ENG-SF21026-R3-GEC.pdf Markup Summary

SHEET: 3 OF 29

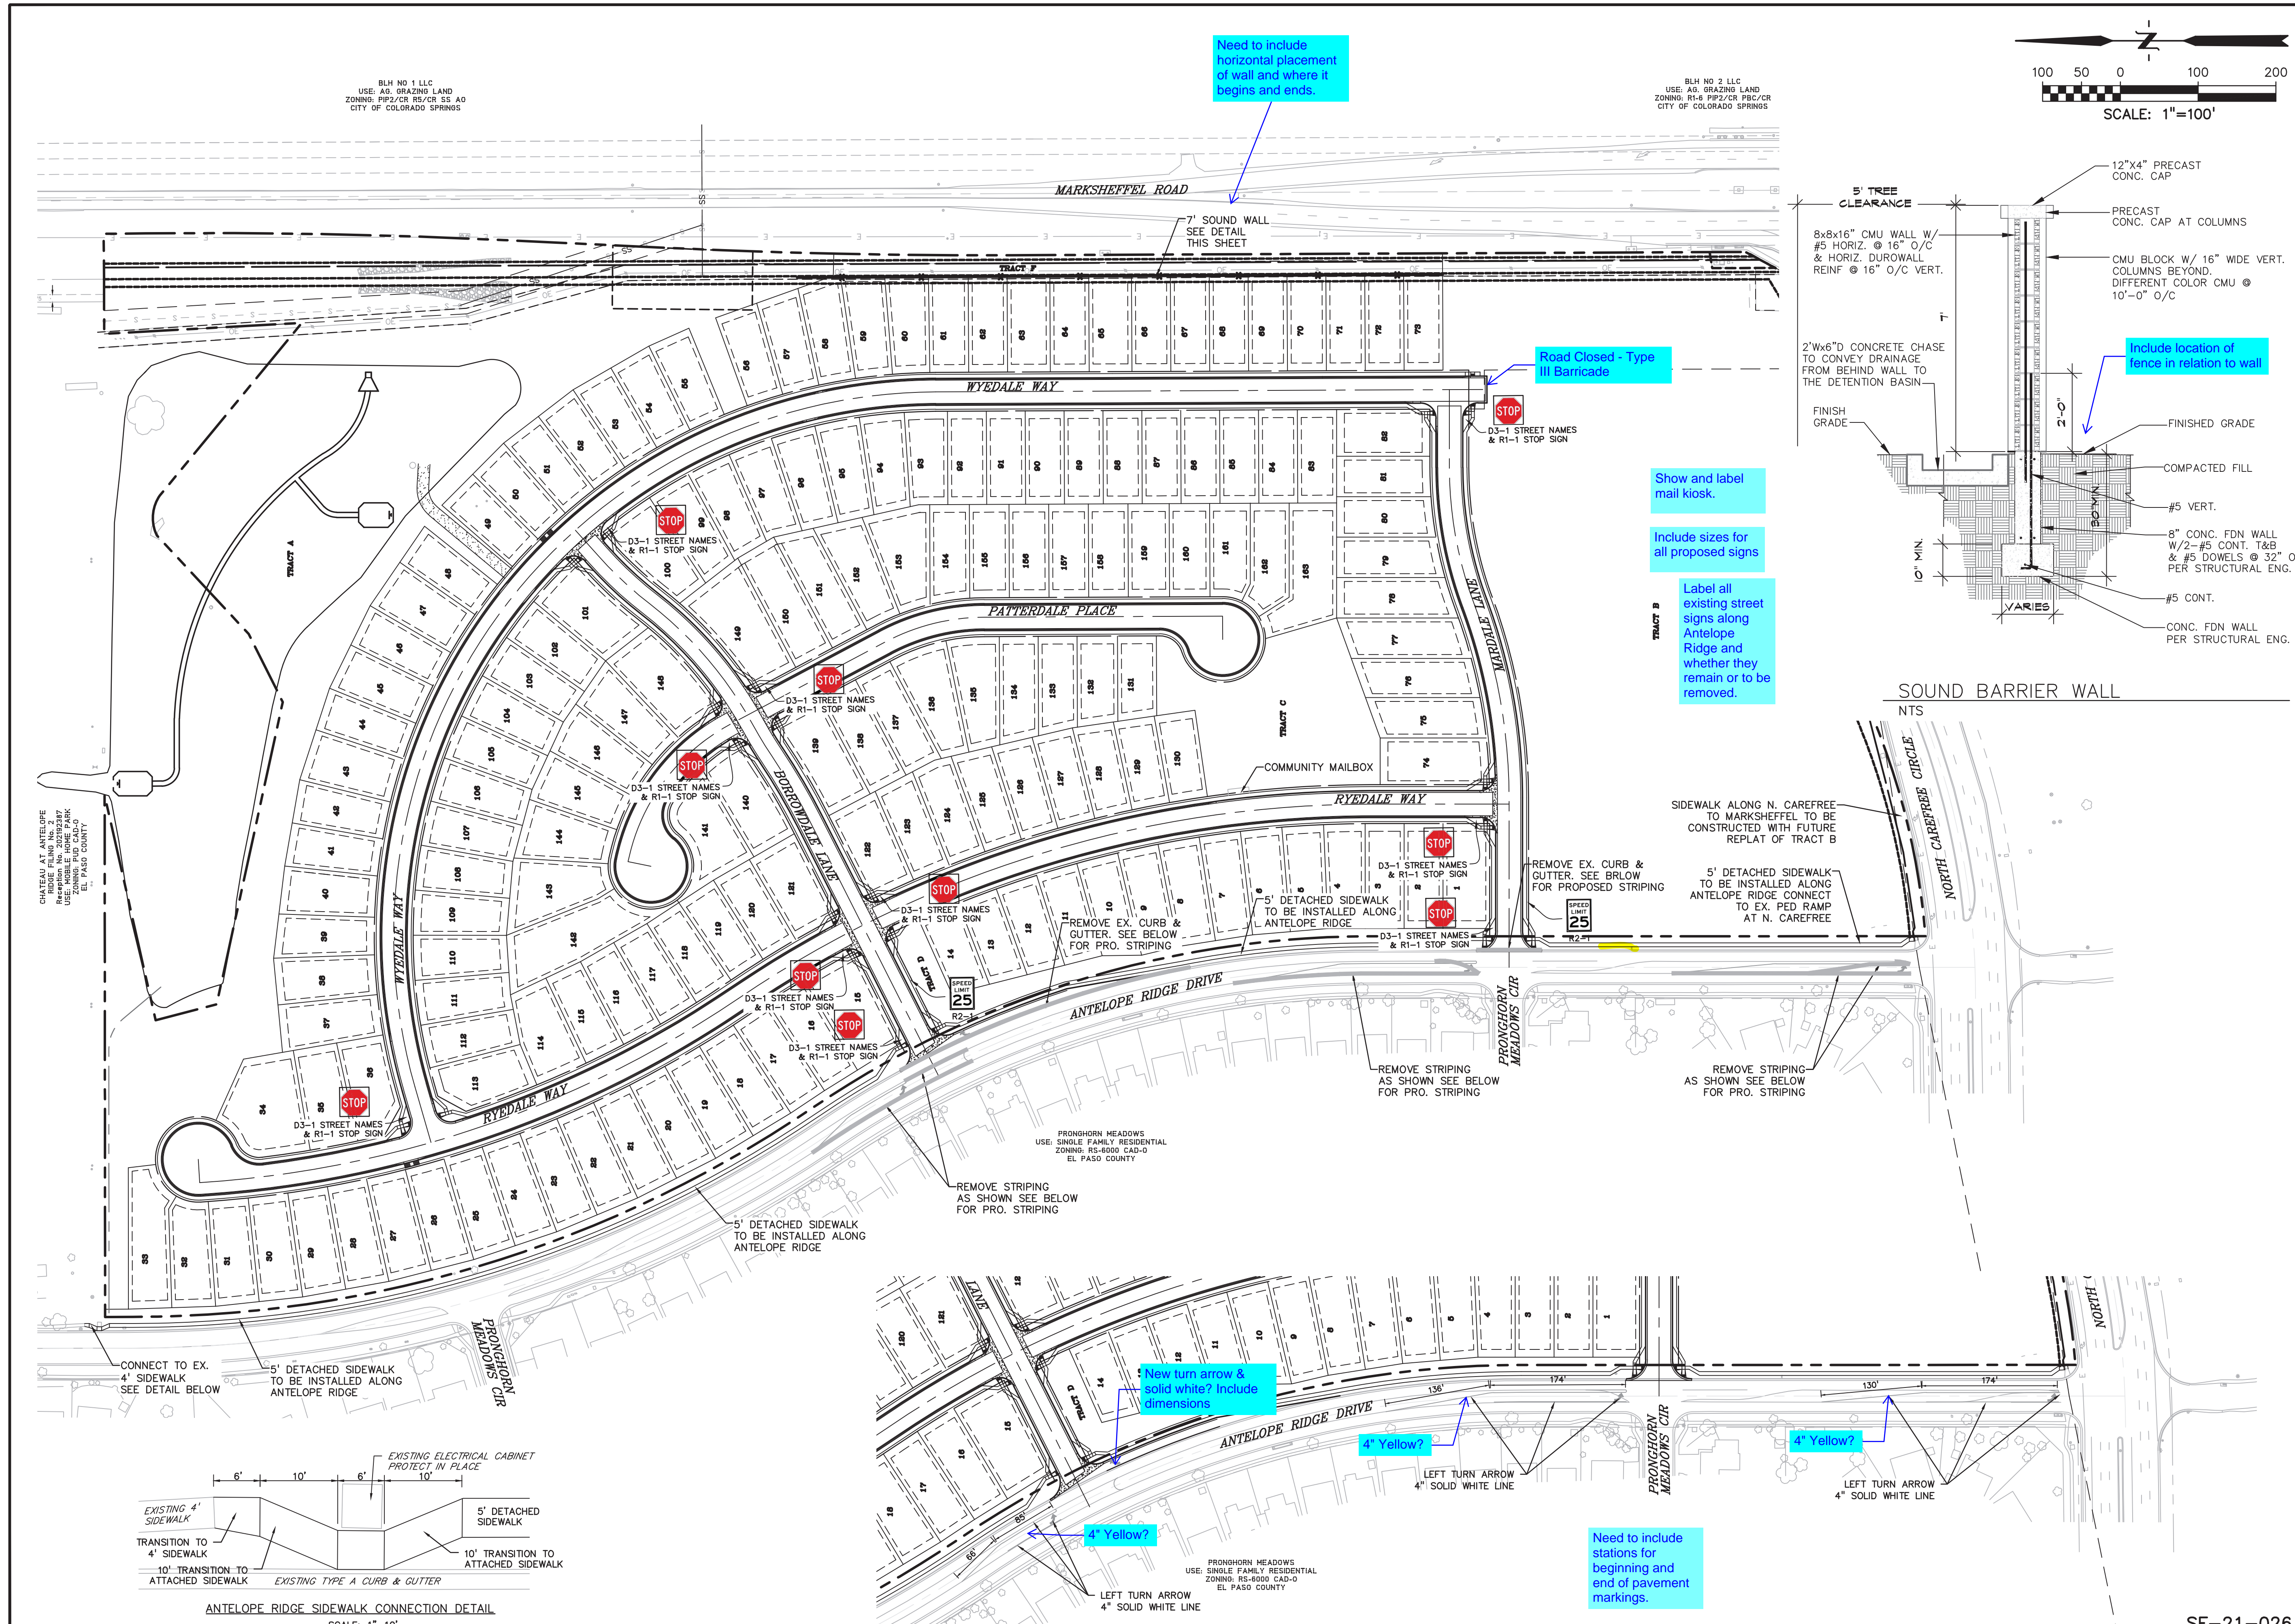
Will this pipe be abandoned?

Yes, label added

SHEET: 8 OF 29

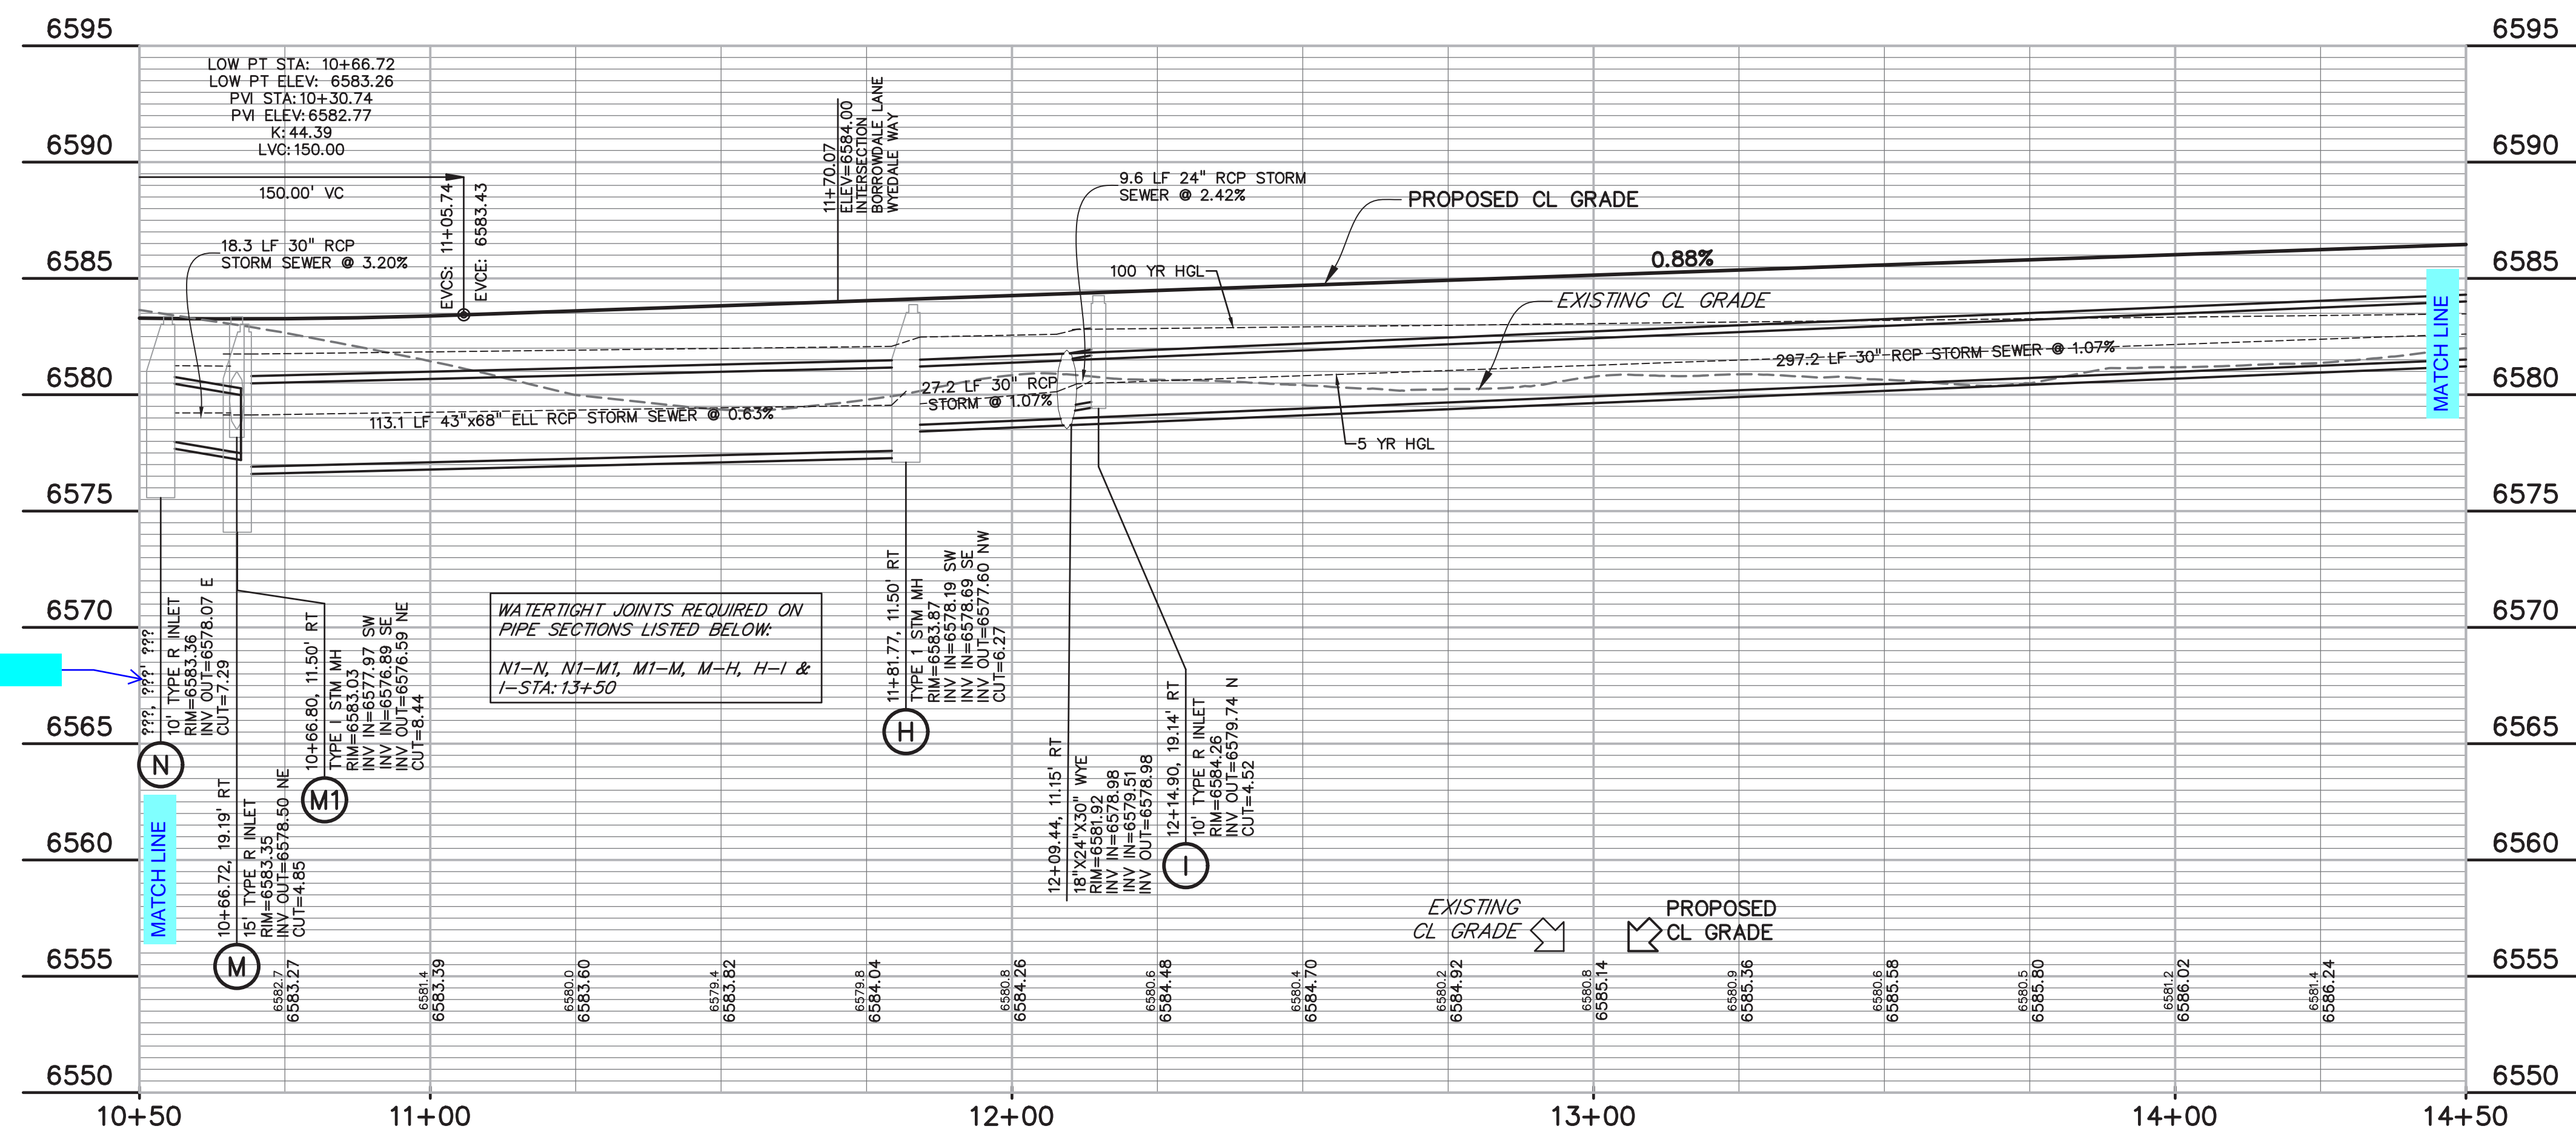
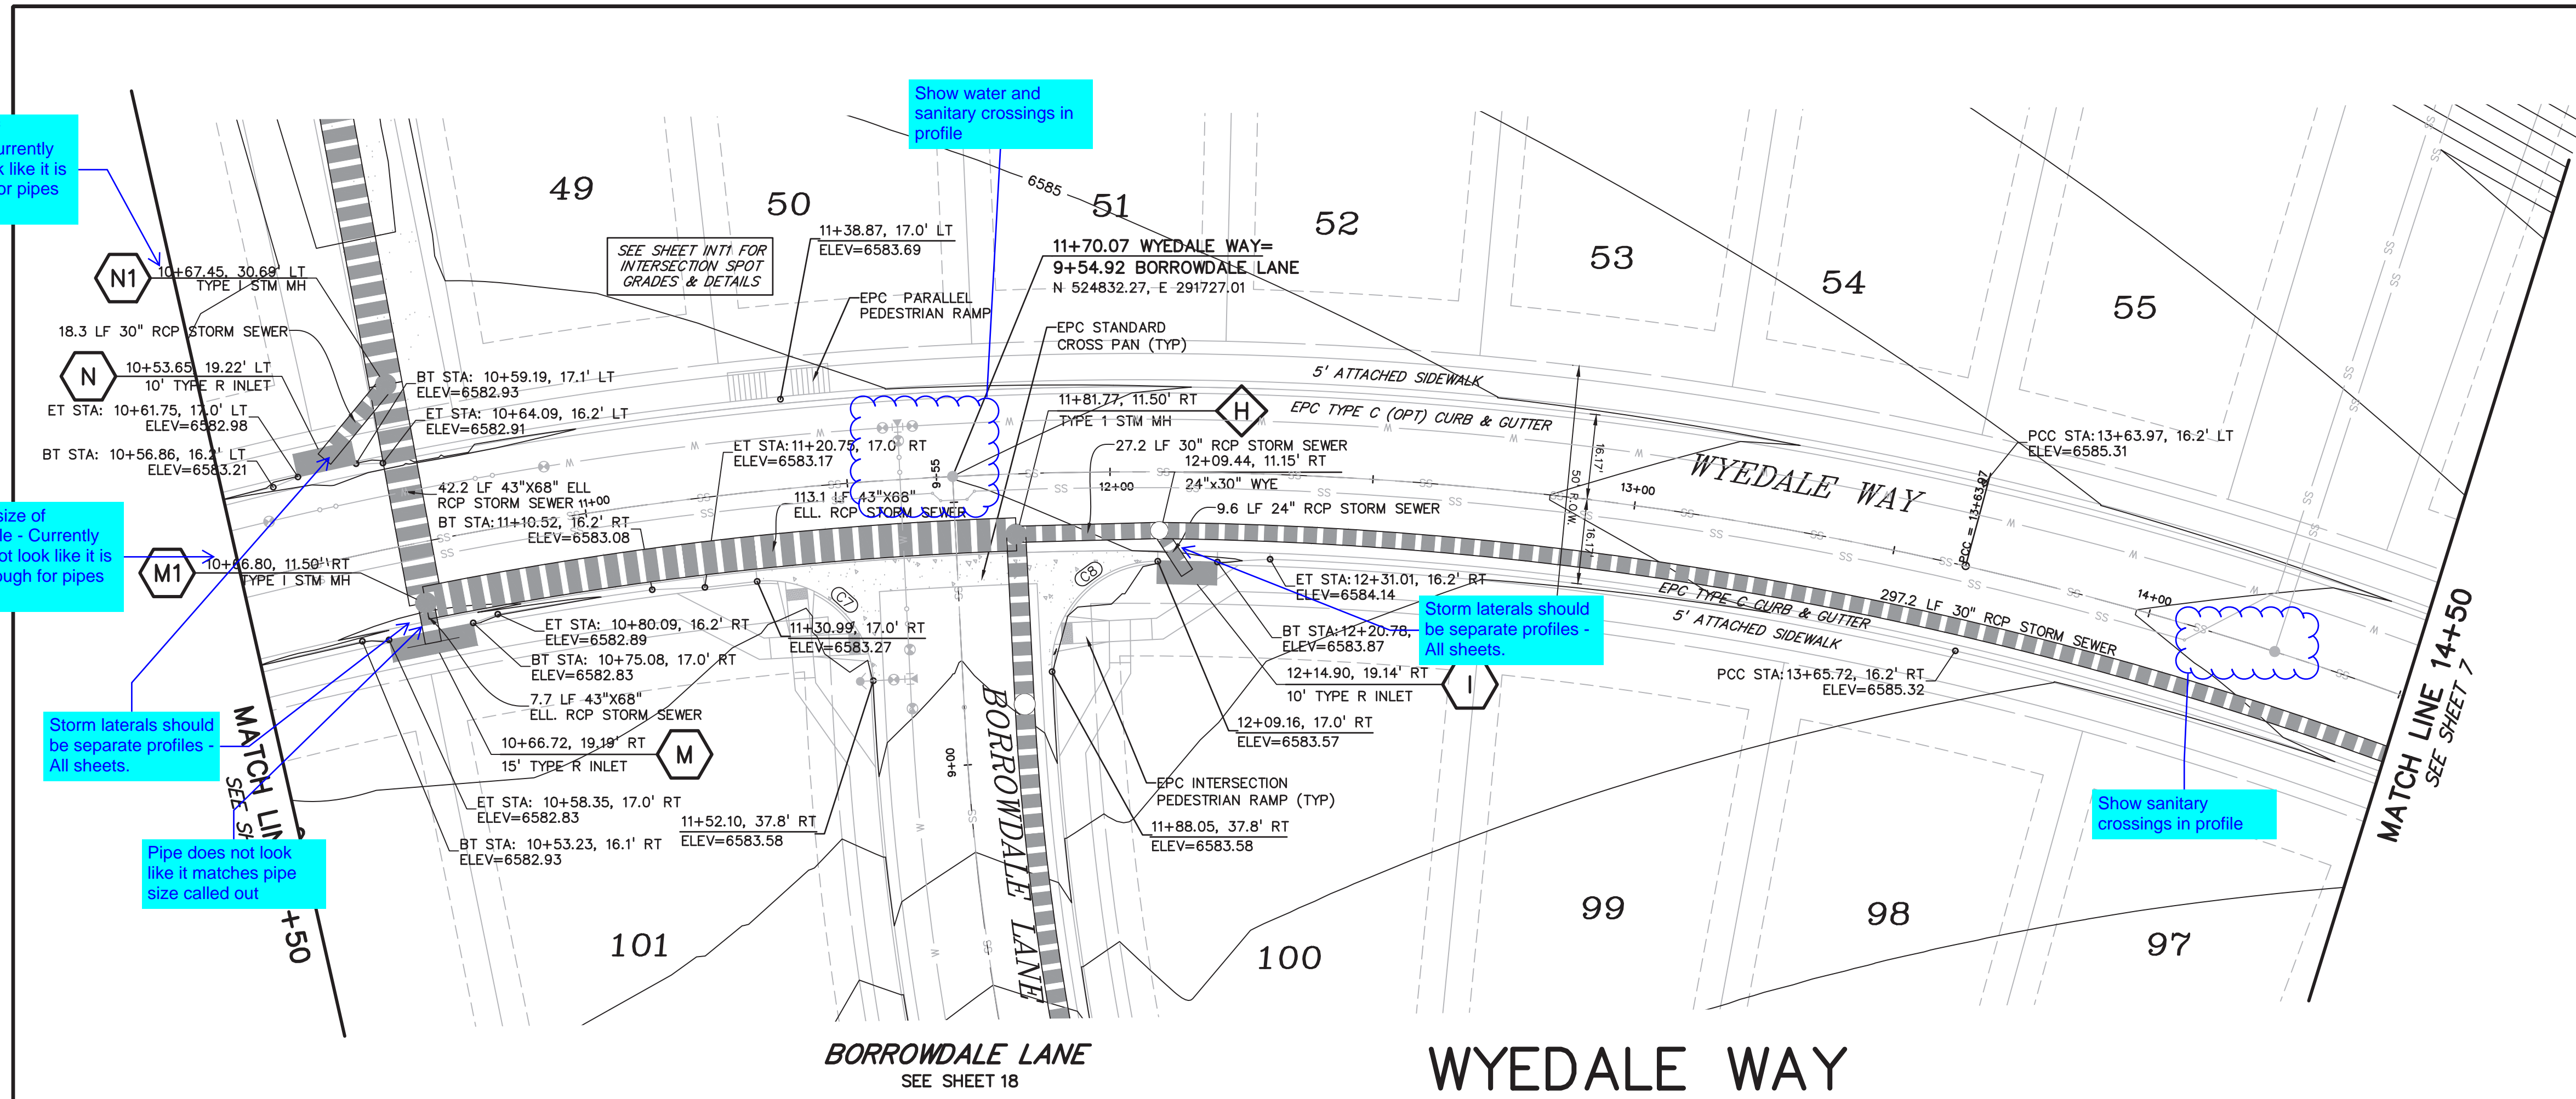
36" pipe will not fit into a Type C inlet.

Bottom of inlet at 6569.00 Please update profile

Need to see north forebay.

15' min. width for access

MHFD Spreadsheet says to use rectangular orifices not circular due to size.

Verify elevation

Label slopes

Show HGL

This is a modified type
C - see detail

profile updated

Viewport extended to
show north forebay

Updated

Updated

Updated

Updated
